Re: Response to RFI dated 17/06/2024 in relation to *Submission of Addendum to the Sediment and Erosion Control Plan for Kings Forest (MP08_0194)* - Environmental Component

Our Reference: 12301-KFP2 [ID 1006370]
State Gov Reference: MP08_0194, DOC21/248960, 12/5212#69

**Re: Response to Information Request in relation to Submission of Addendum to the
Sediment and Erosion Control Plan for Kings Forest (MP08_0194)**

PROJECT
Threatened Species Management Plan
Precincts 1 - 5 Kings Forest
Melaleuca Drive, Durranbah, NSW
Shire of Tweed

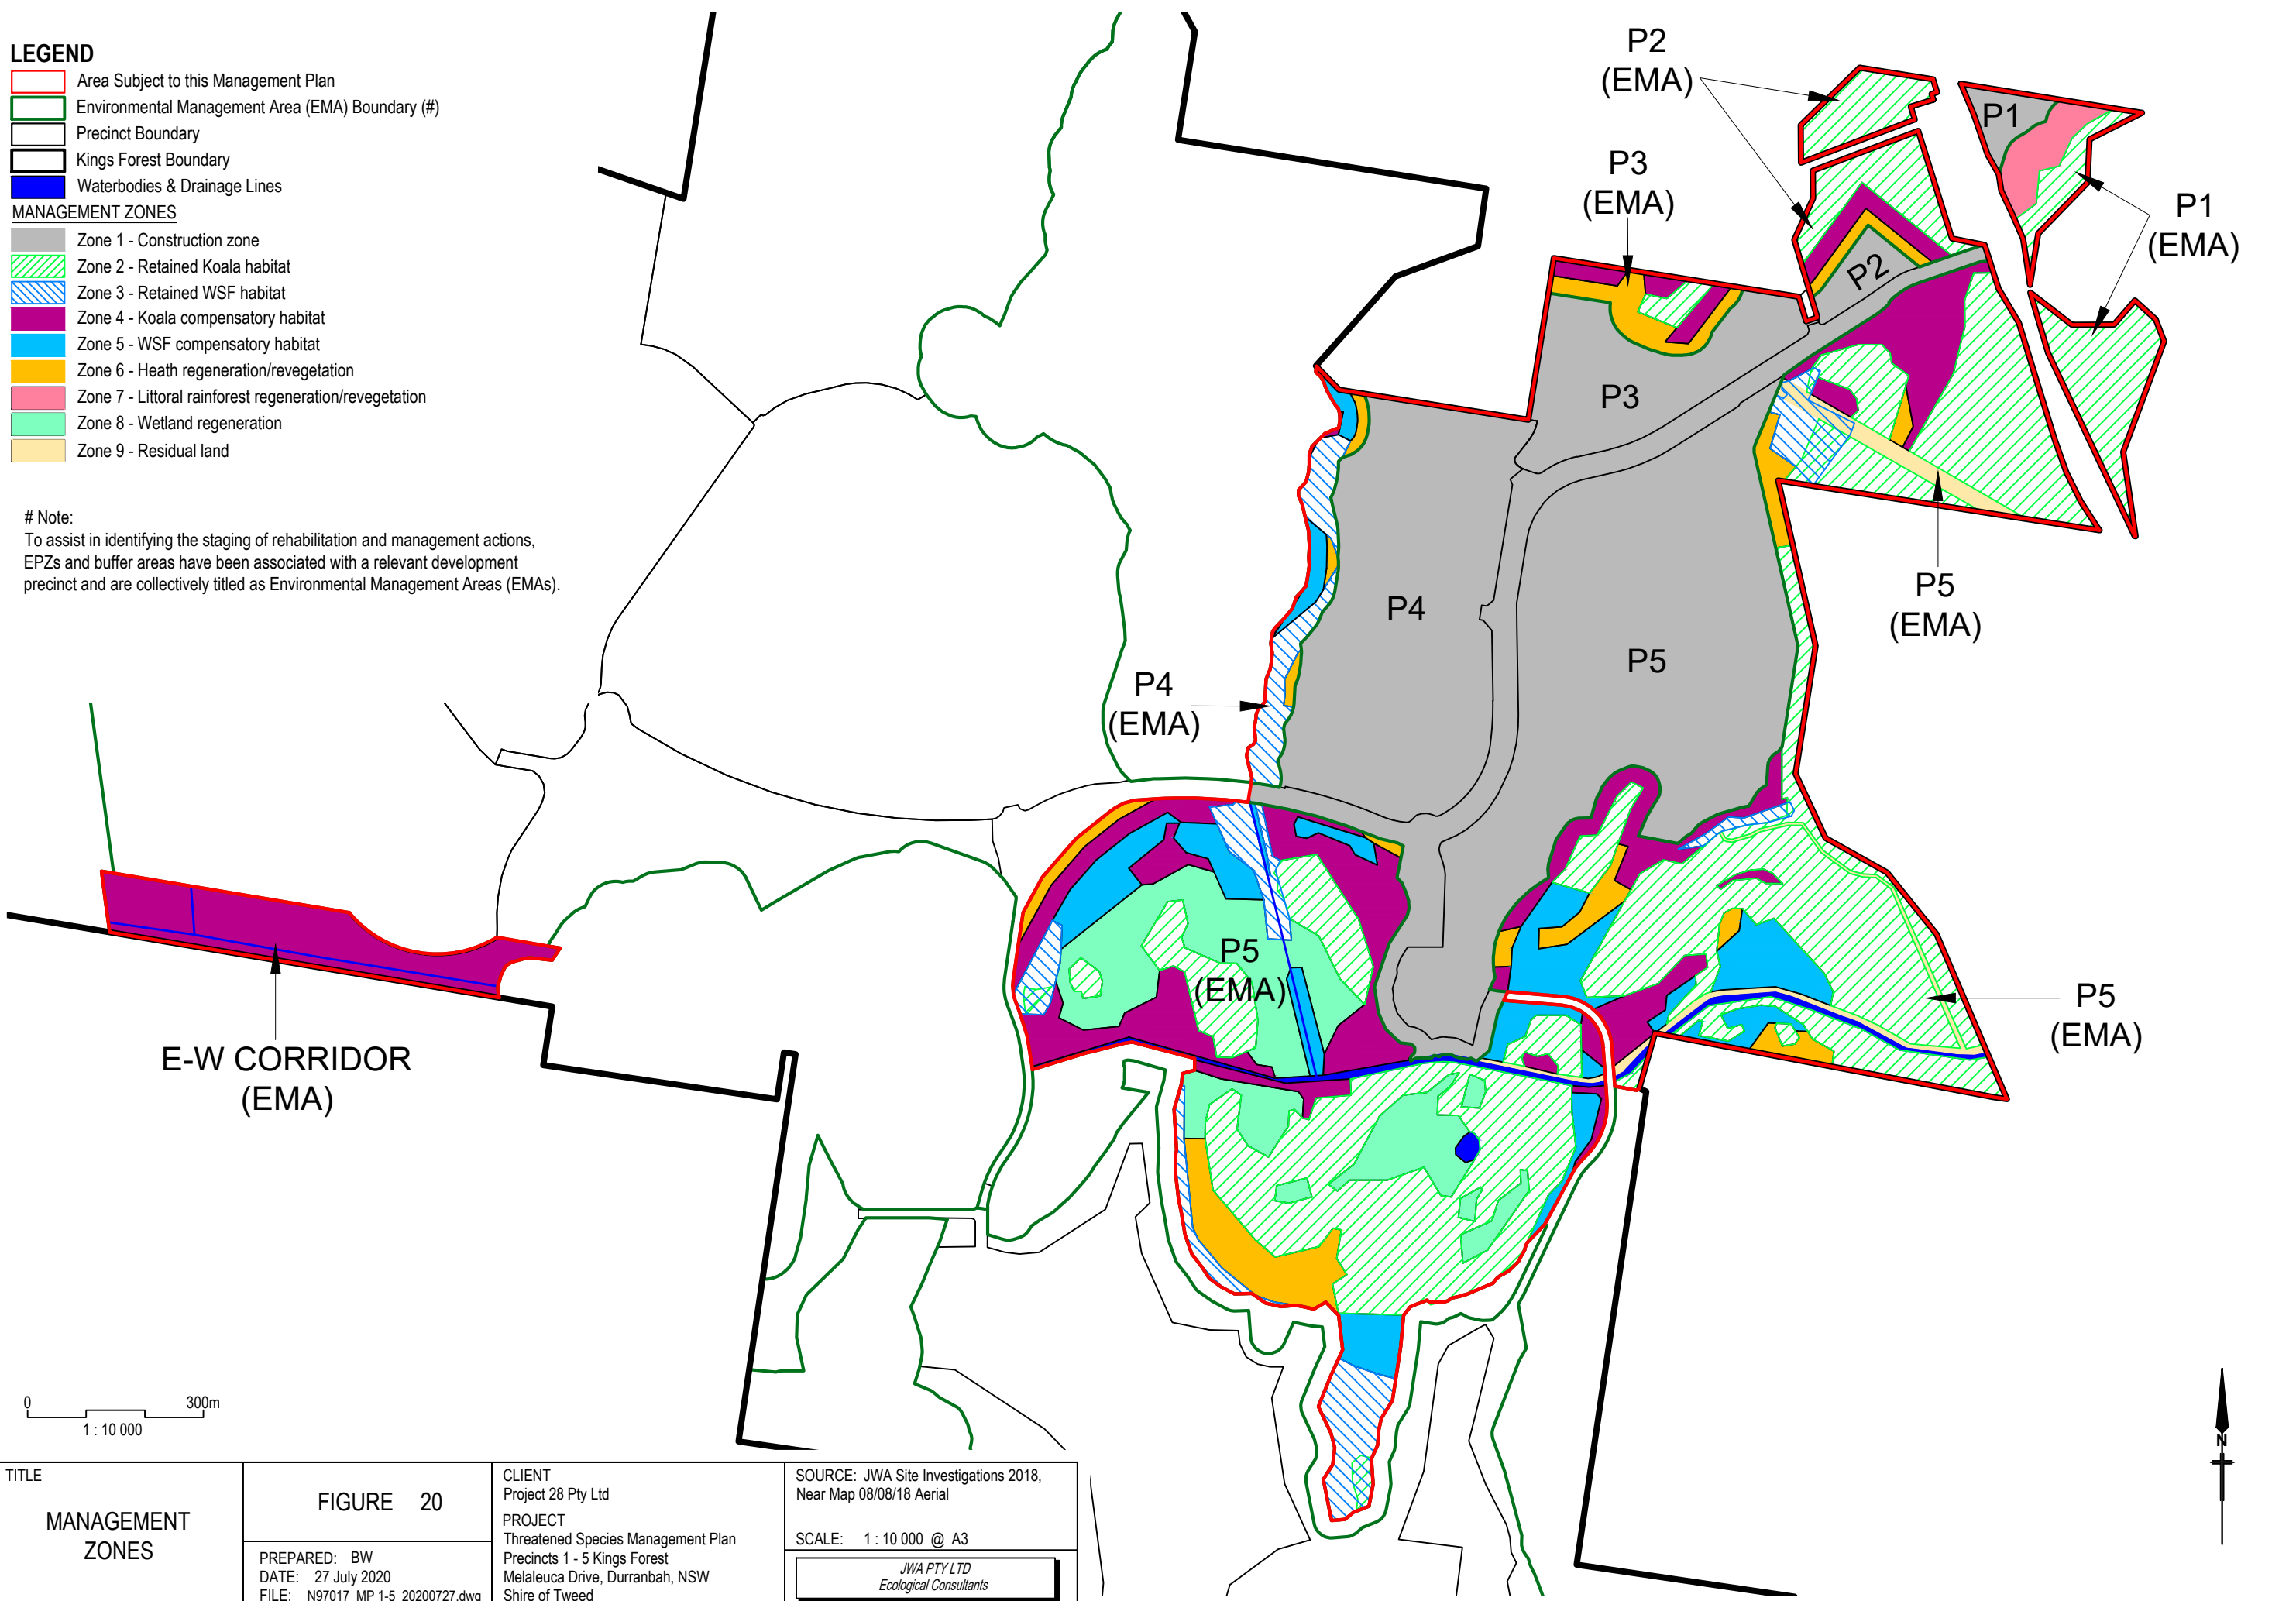
“The construction zone consists of the development footprint of Precincts 1 - 5. The development footprint also includes the 20 m outer buffer zone adjacent to Precinct 5 which will be utilised for stormwater conveyance and ancillary structures such as fauna exclusion fencing (FIGURE 20)”.

- The location of the proposed treatment system is confined to the area known as Zone 1 - Construction Zone in accordance with Figure 20 of the Threatened Species Management Plan (JWA 2021 (overleaf)). Works will be undertaken within the 20m outer buffer zone however as per the project approval MP08_0194 this is within the approved road reserve for Kings Forest Parkway.
